# Roadway Plans\_V1.pdf Markup Summary

# CLEARWAY FILING NO. 2, LOT 5

# CONSTRUCTION PLANS

CLEARWAY, LOT 5	
OUTLET STURCTURE POND 1 DETAILS	
PROJECT NO. 44-042A	DATE: 09-09-2022
DESIGNED BY: DLM	HORIZONTAL: 1"=50'
DRAWN BY: CLP	VERTICAL: 1"=5'
CHECKED BY: DLM	SHEET 15 OF 16
BMP02

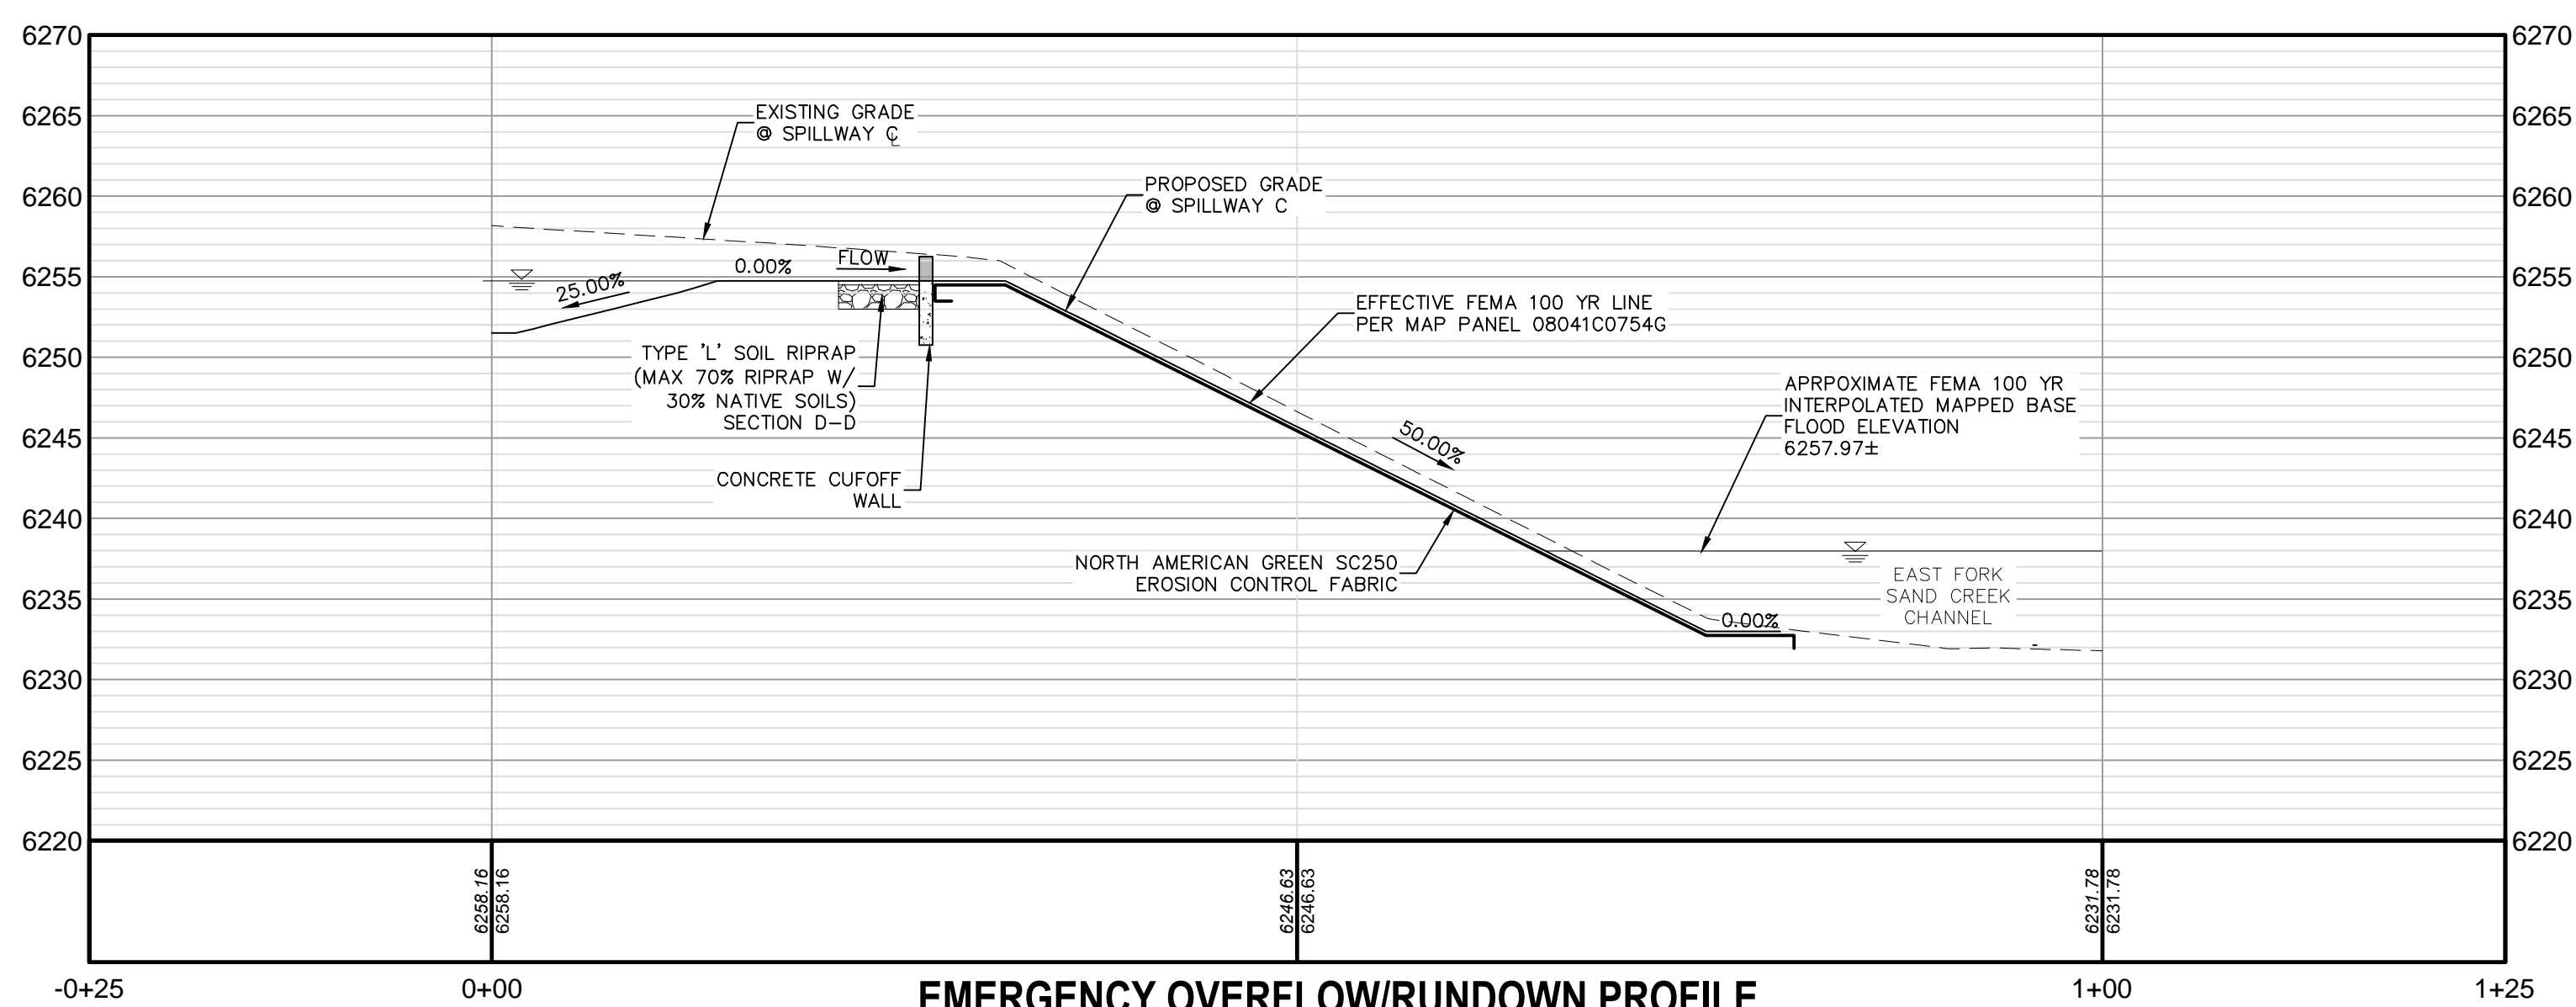
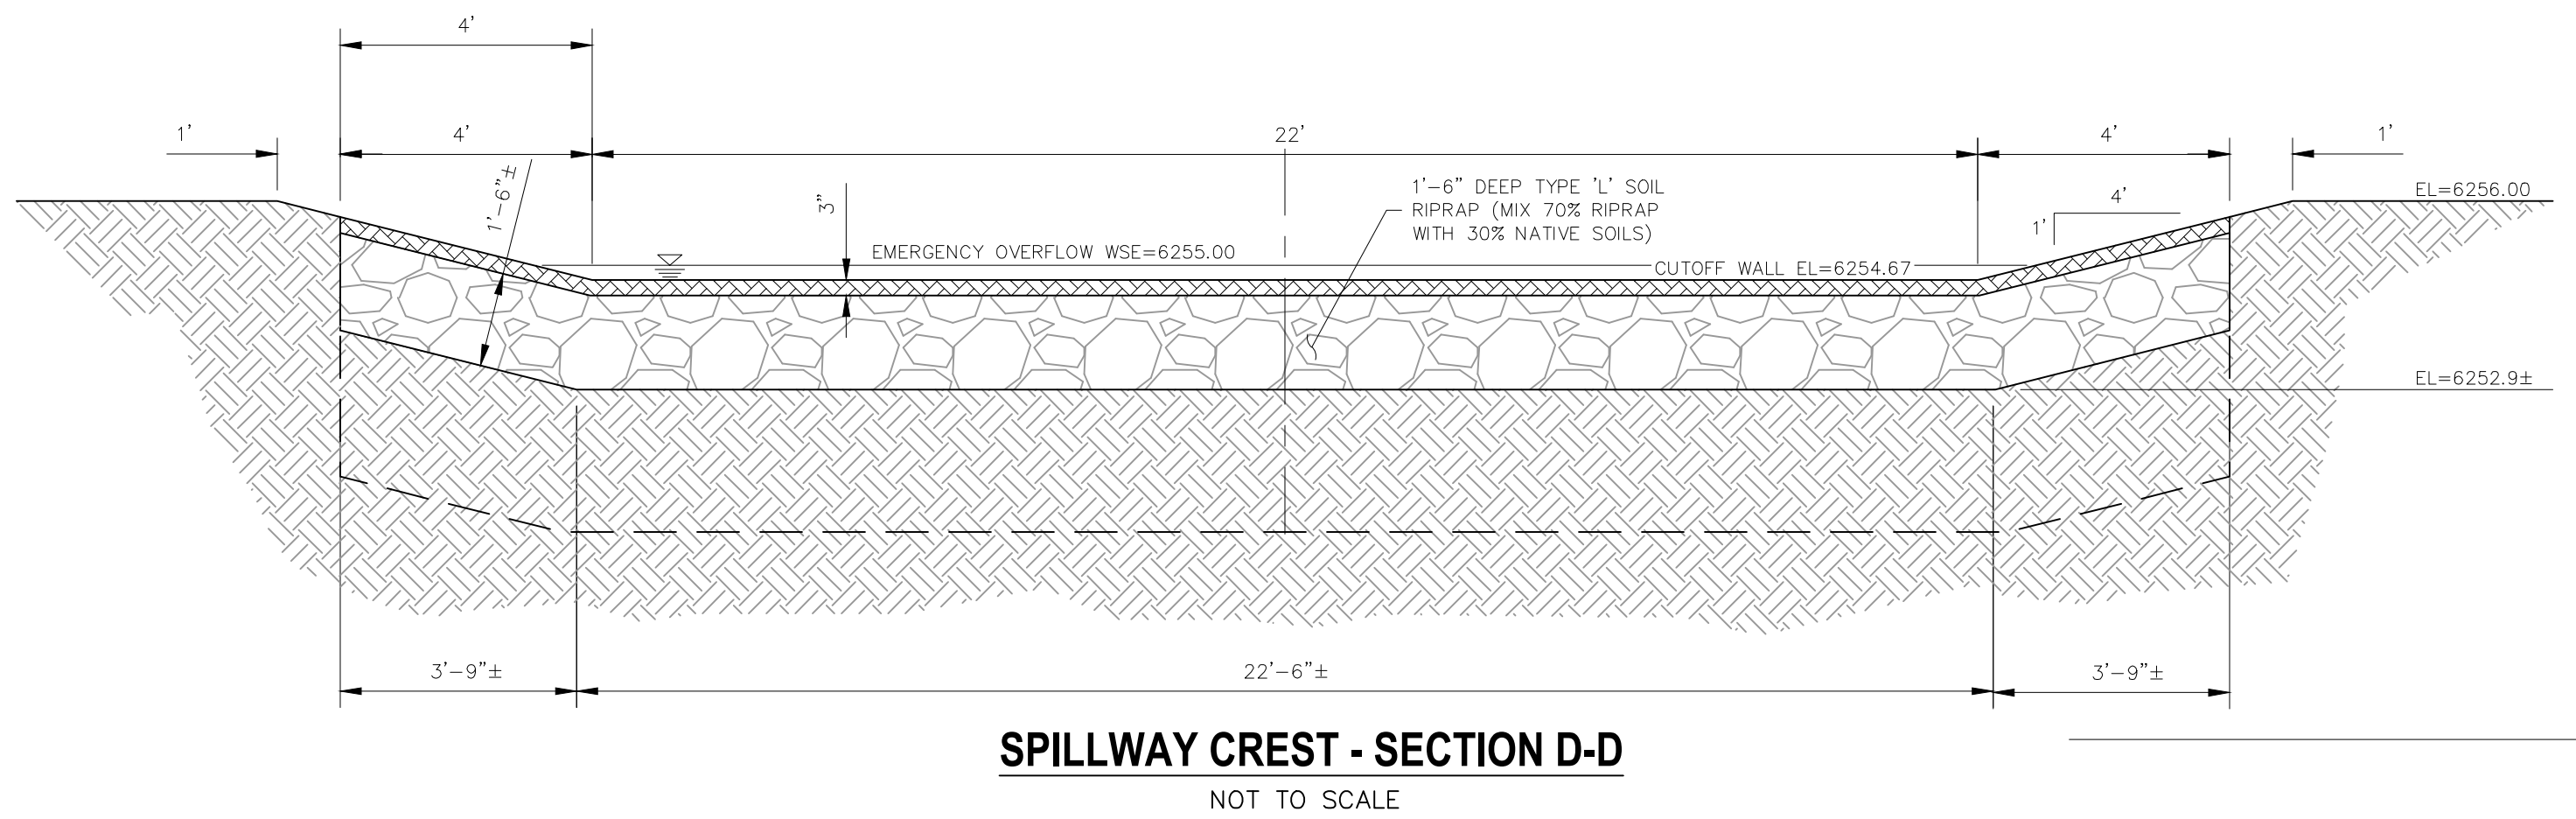
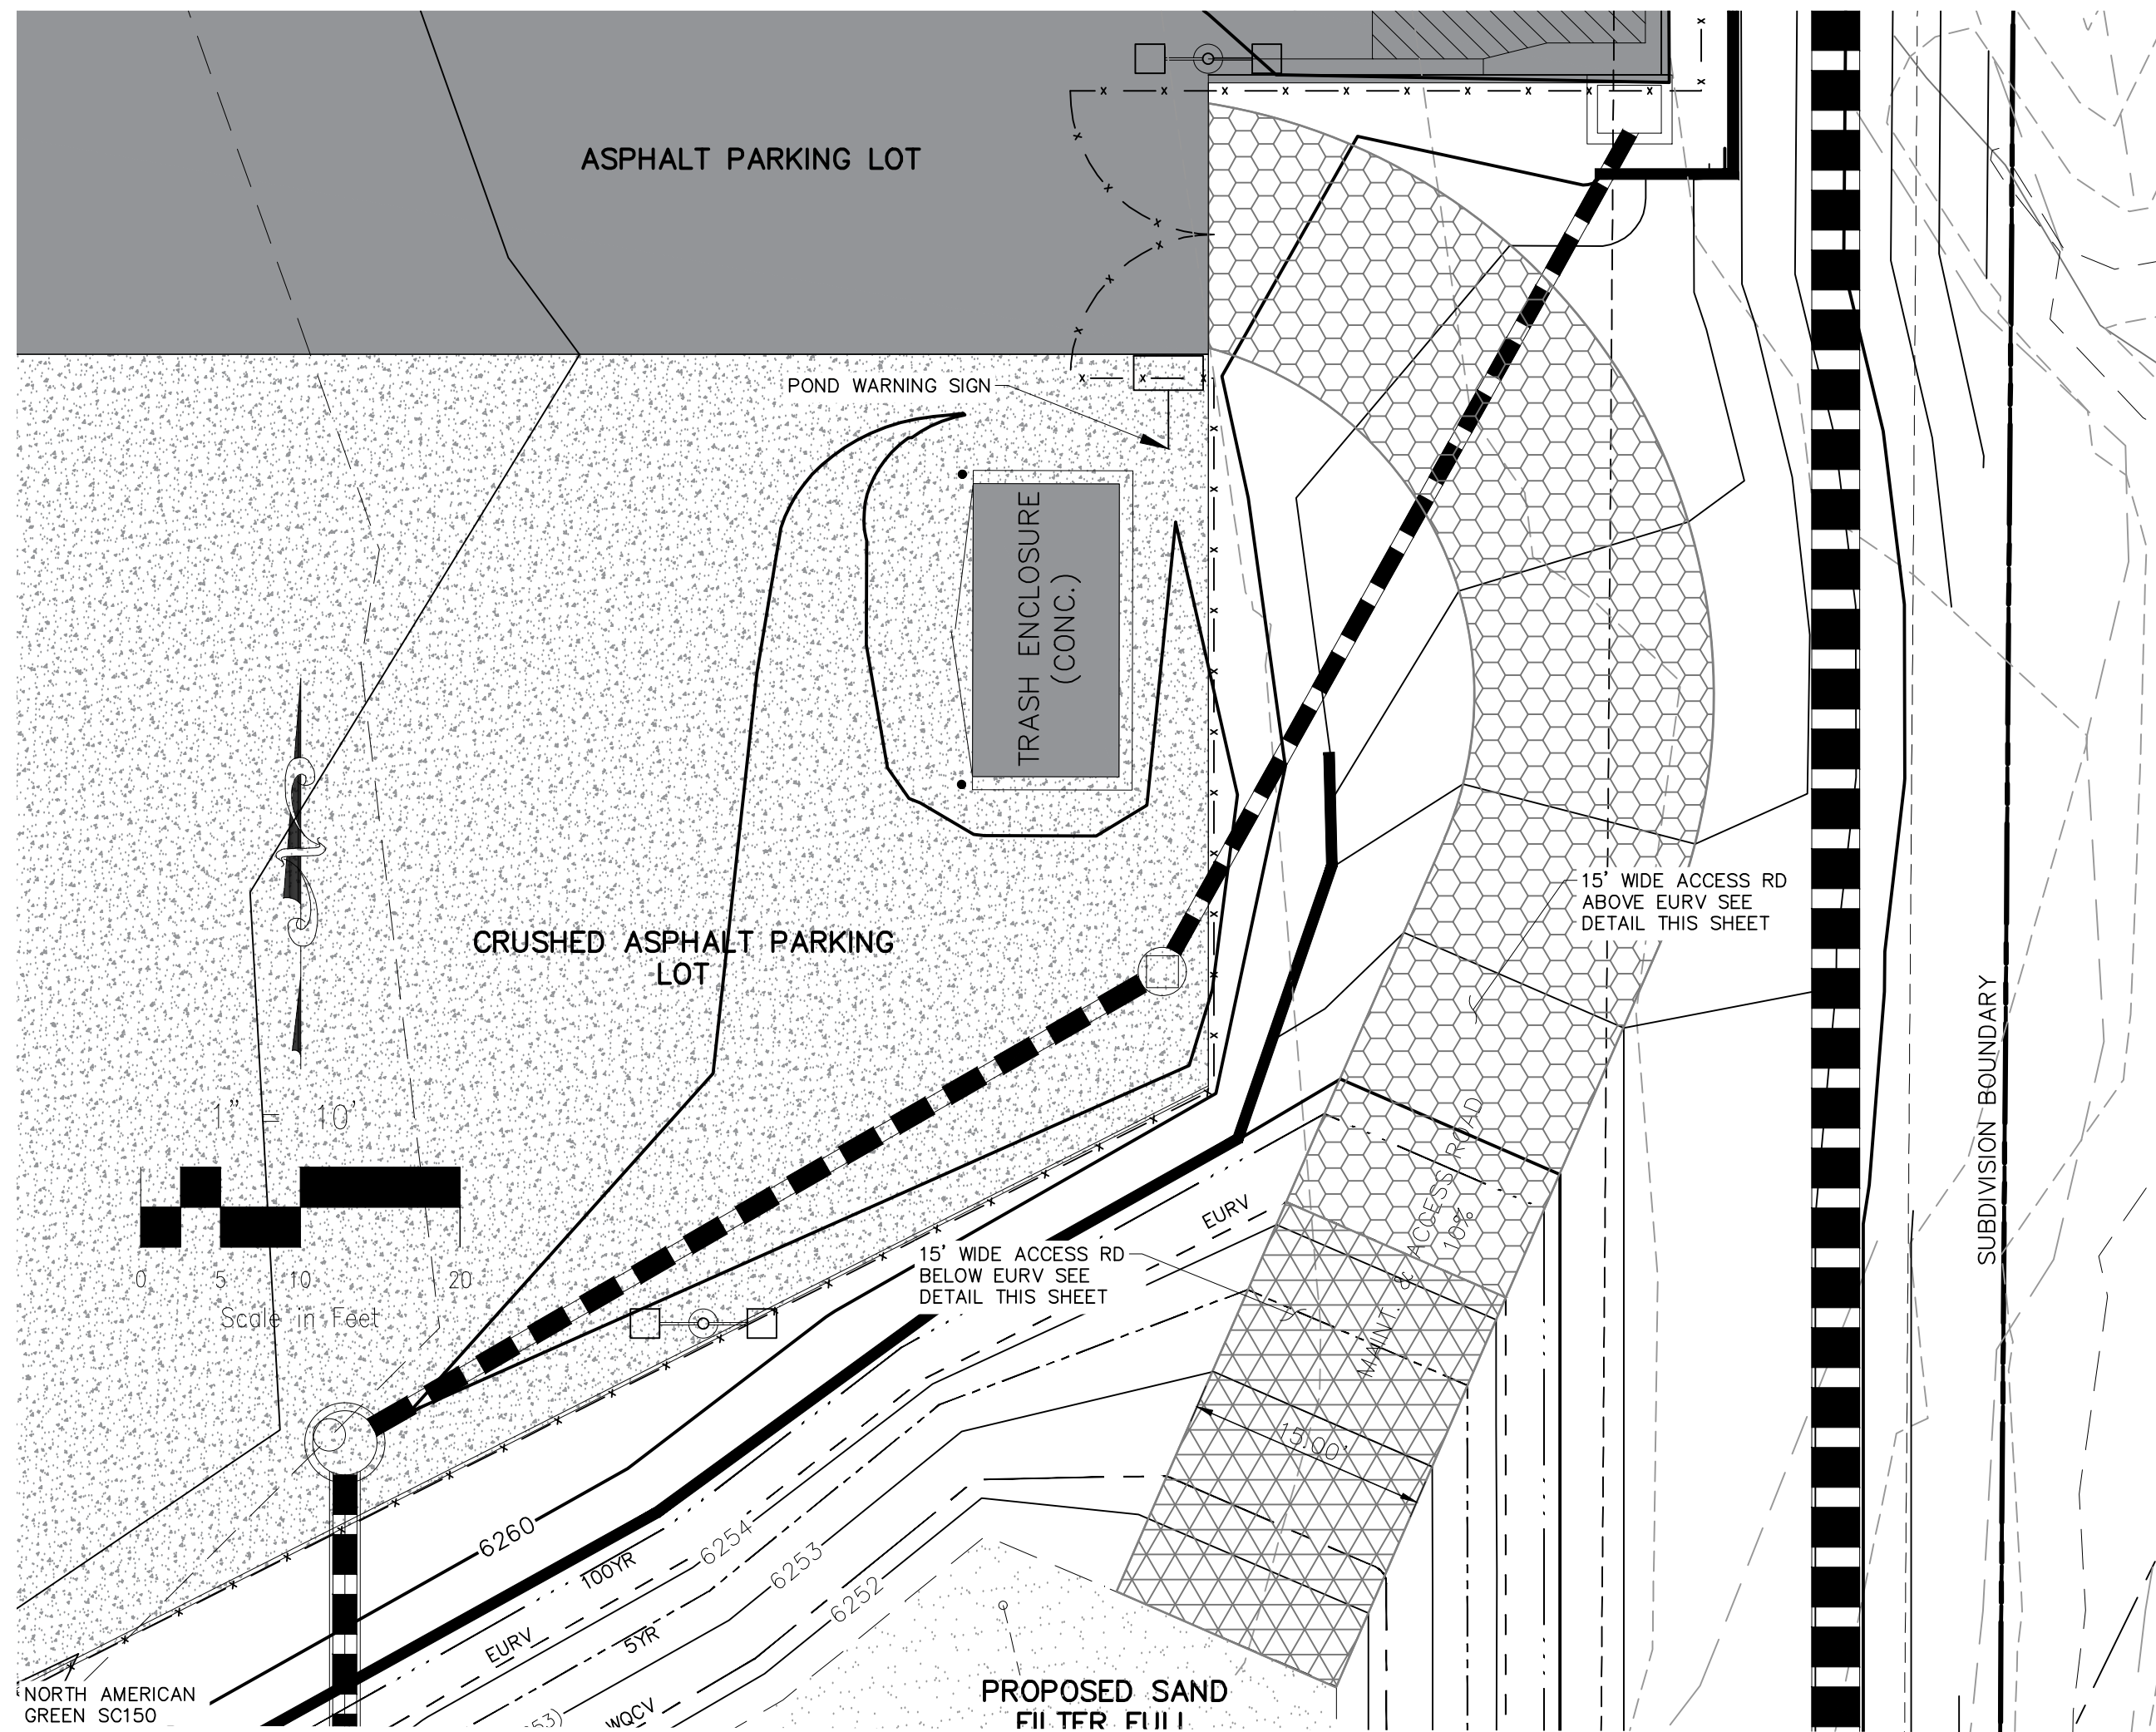
tie all proposed contours to existing

the drainage report indicates that the spillway is designed for 12.8 cfs (rational flow). Revise accordingly.

revise/clarify all section labels

Provide riprap gradation table and note that CDOT Section 506 Requirements apply.

include dimensions on plans
